### ABLE MARINE ENERGY PARK (Material Change 2 – TR030006)

## **Proposed Able Marine Energy Park (AMEP) Quay Material Change 2 Application**

**Case Reference: TR030006**

**March 2021**

Project: **ABLE Marine Energy Park**  
 Client: **ABLE UK Limited**  
 Drawing Title: **Indicative Masterplan Changes**

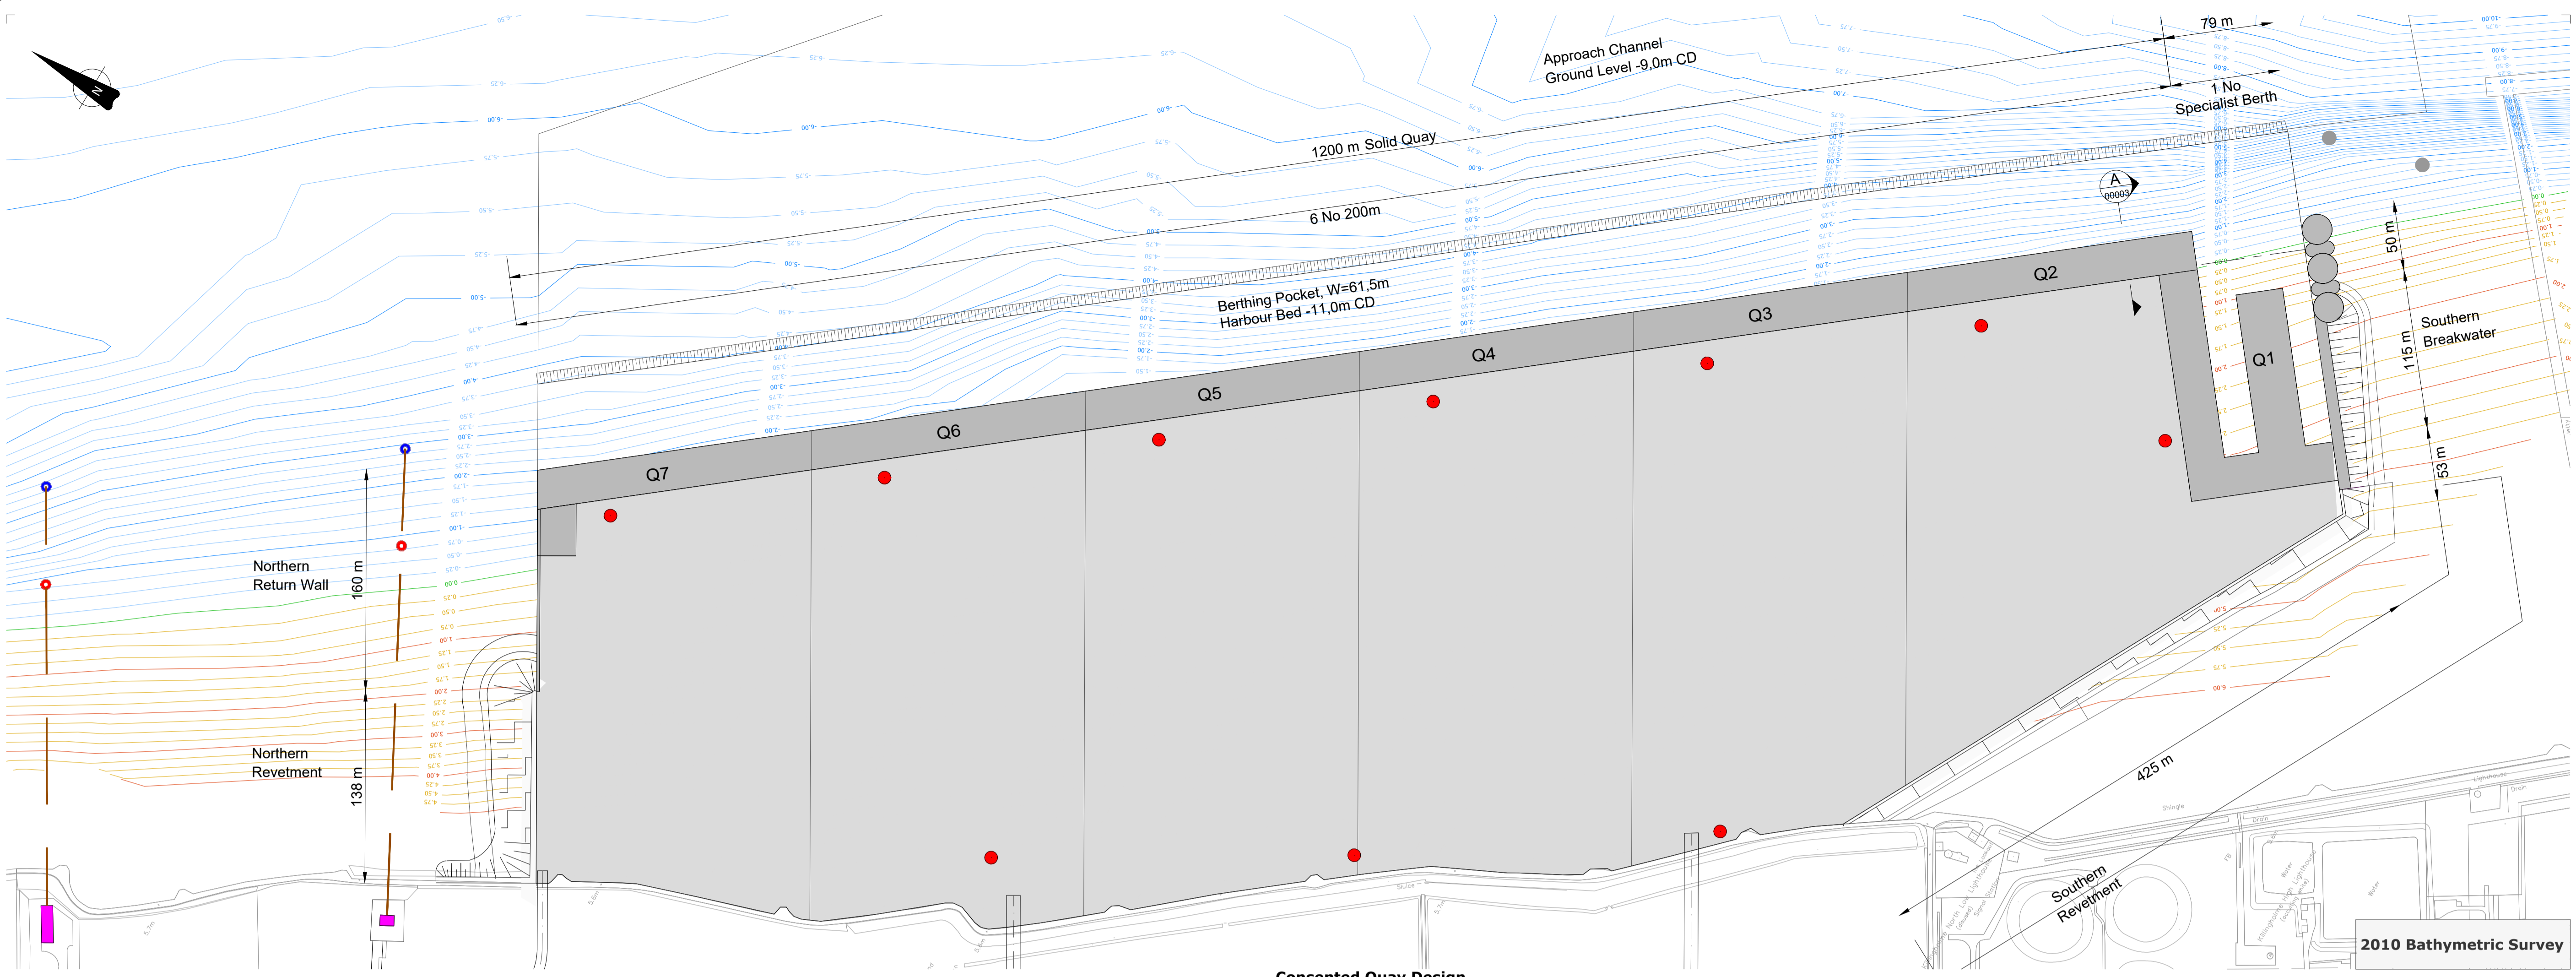
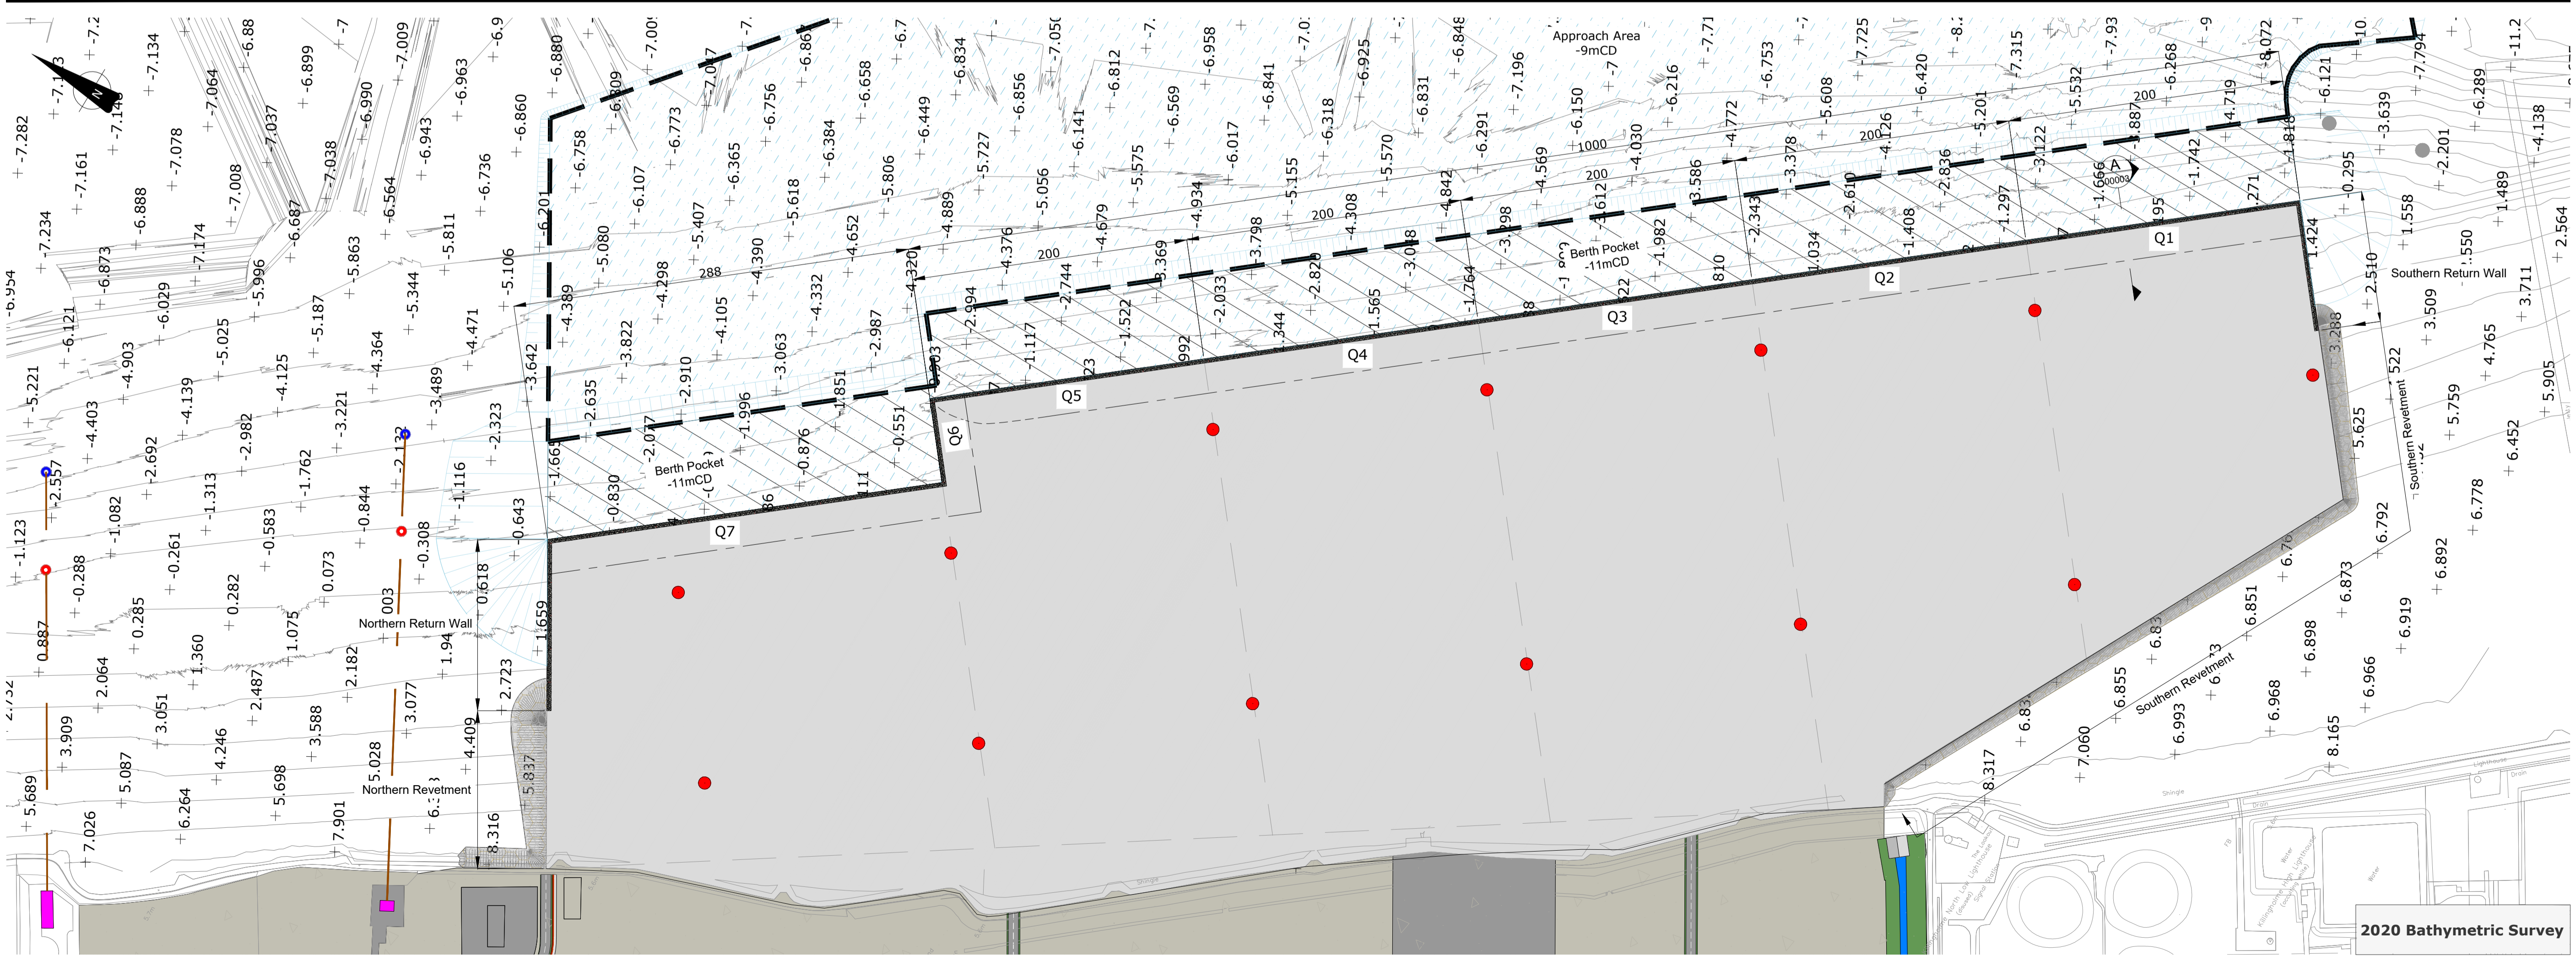
- 2.3.4 The consented scheme includes a specialist berth which is to be omitted from the changed scheme. Instead a barge berth is to be located at the northern end to enable barges and Ro-Ro vessels to berth and load/unload directly. The report explains that changes to the quay would facilitate Ro-Ro operations by allowing self-propelled mobile transporter (SPMT) units. Impacts associated with increased vessel movements and the change in the quay line are to be scoped into the updated ES. The report describes the use of SPMTs as having been fully assessed within the original ES. There is no reference as to where this information can be found in the ES and so it is not clear how or what has been assessed in relation to the use of SPMTs. For clarity the updated ES should provide specific reference to the location of this information in the original ES.
